Application for Removal or Variation of a Condition following Grant of Planning Permission or Listed Building Consent

Erection of extension, internal and external alterations, including parking area, bike shed and patio to Carlecoates Hall Stables

2024/0719

Update noted on drawing reference '20240617-CH-04-Proposed Detailed Floor Plans ElevationsR.08'

PROPOSED NORTH EAST ELEVATION// SCALE 1:50@ A1

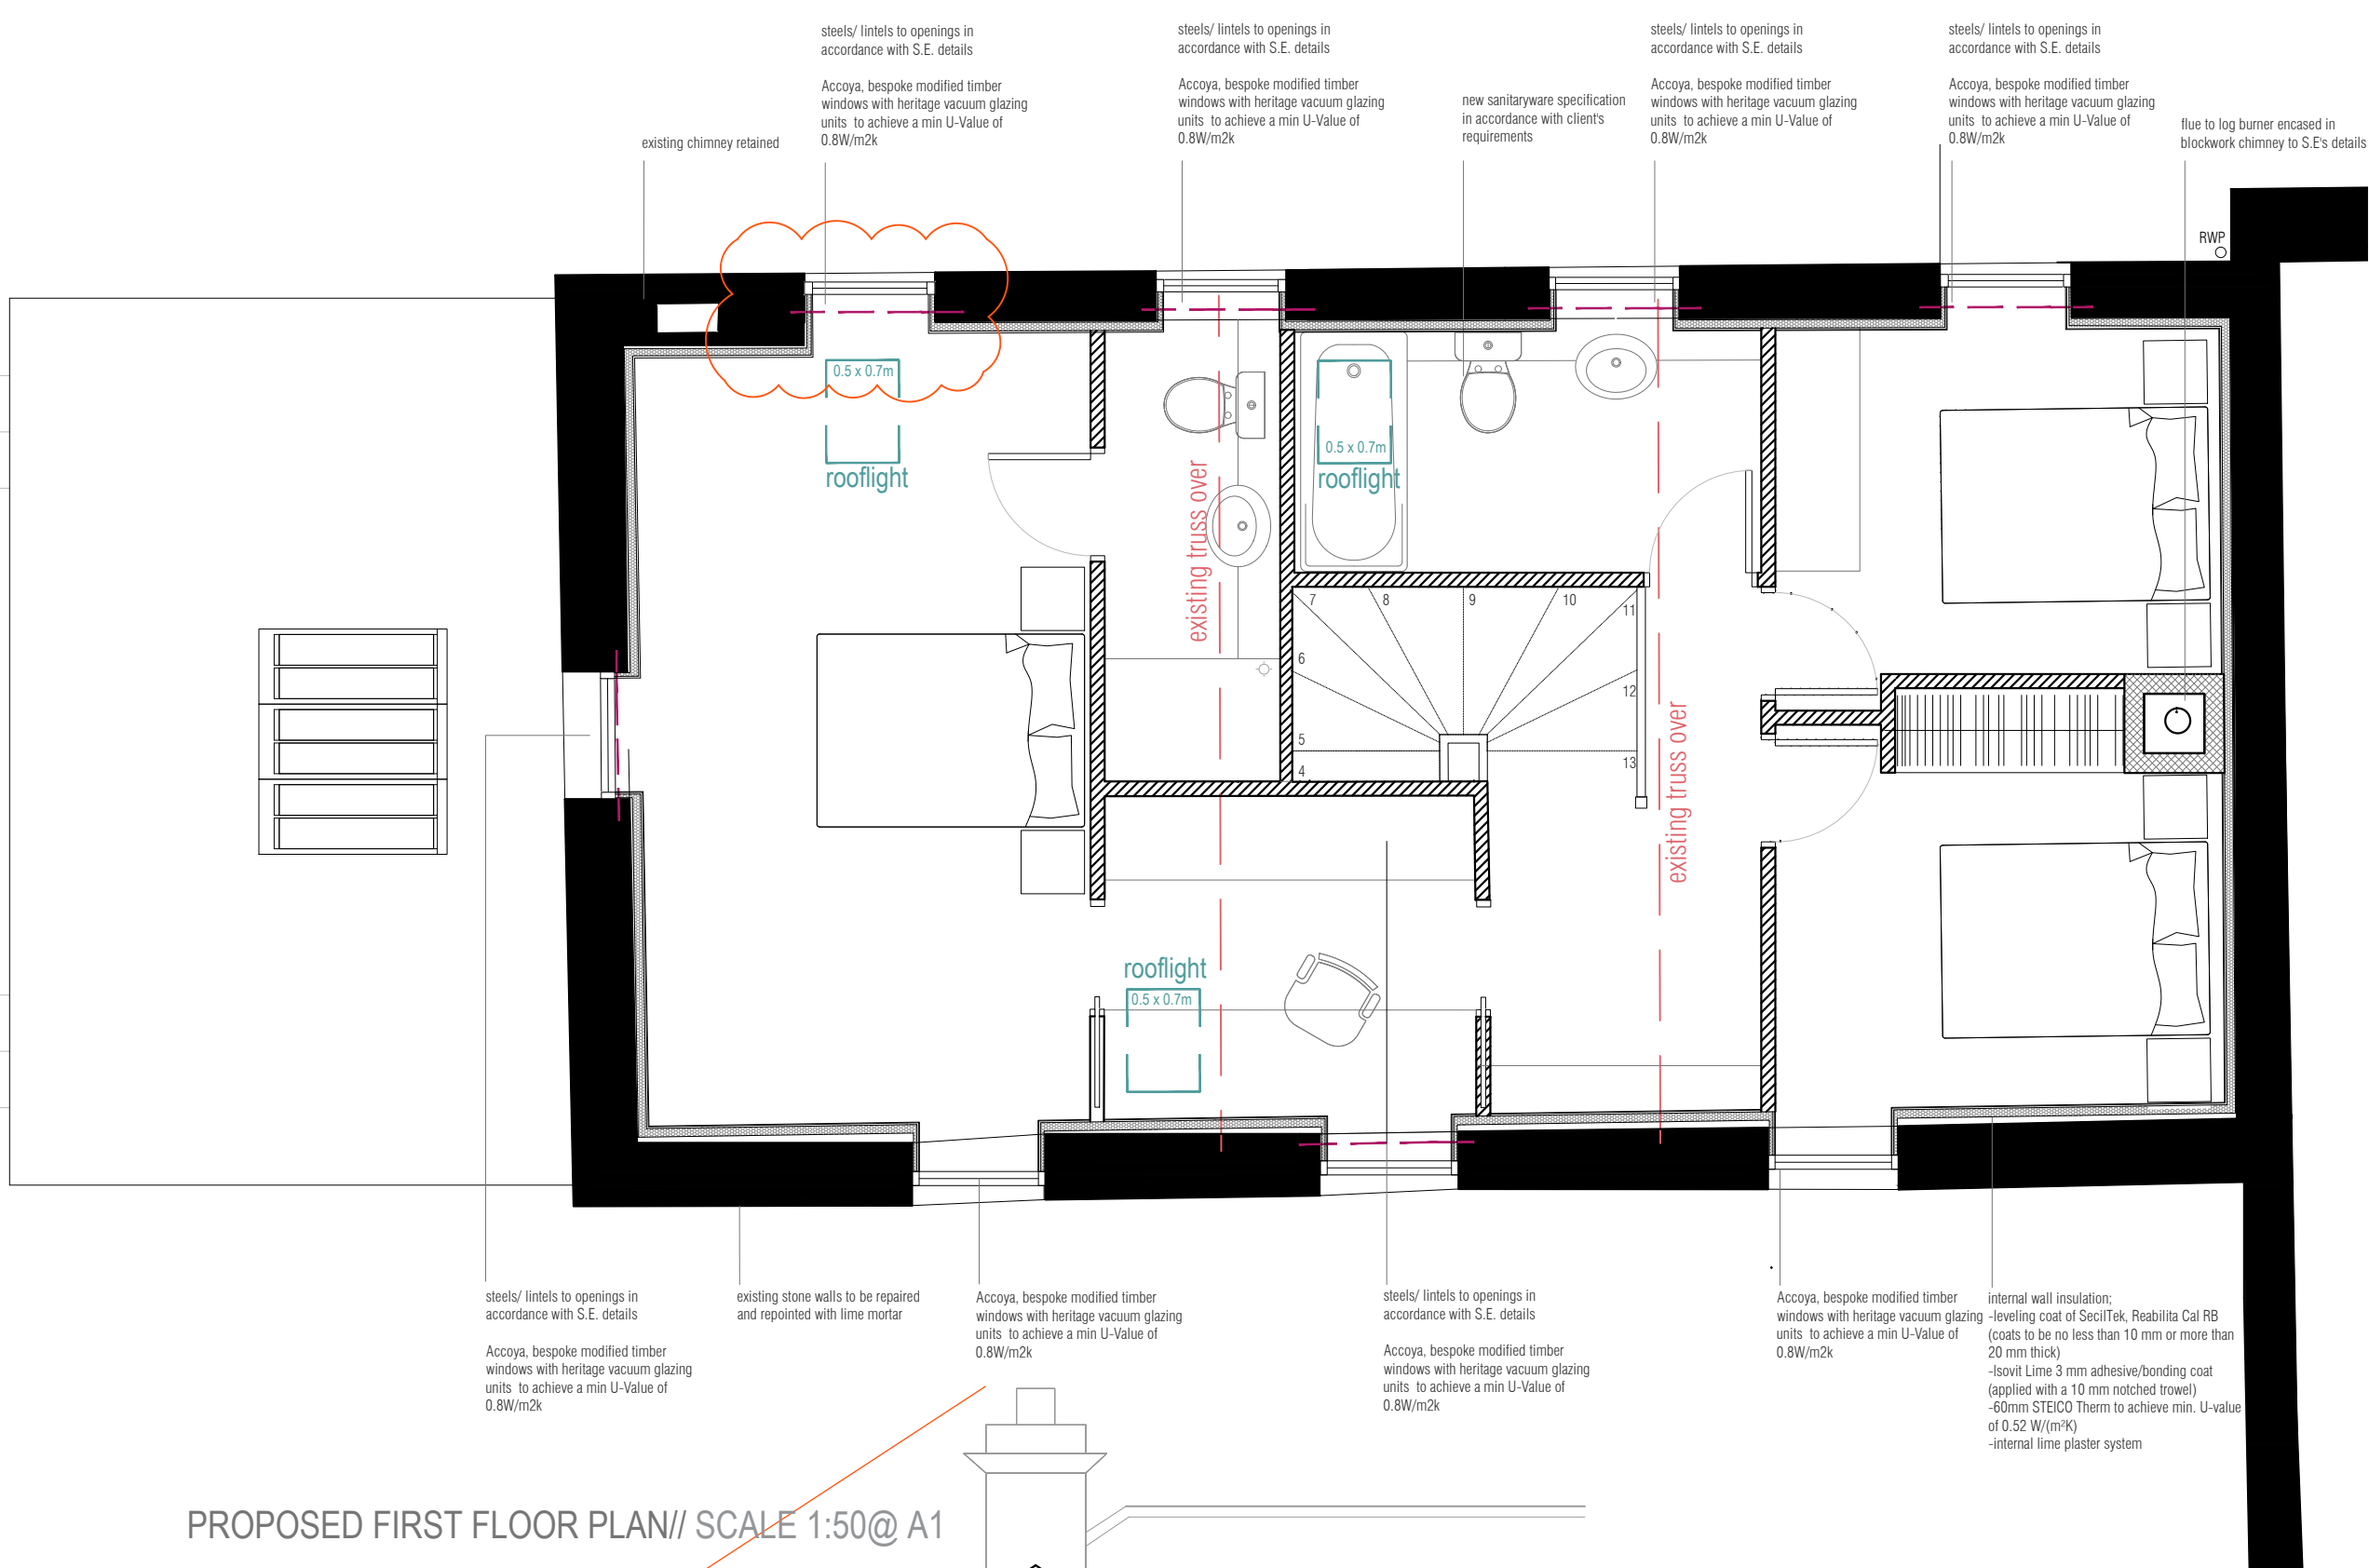
Addition of new window to North East elevation at first floor. It is proposed that the design and materials will match that of the other windows, comprising dressed Millstone Grit window surrounds and timber window frames.

The additional window is proposed to provide more balance to the elevation, achieving a more symmetrical aesthetic, which feels more fitting for a 17c buildings.

Condition to be updated to reference revised proposed drawings. Amendments noted above
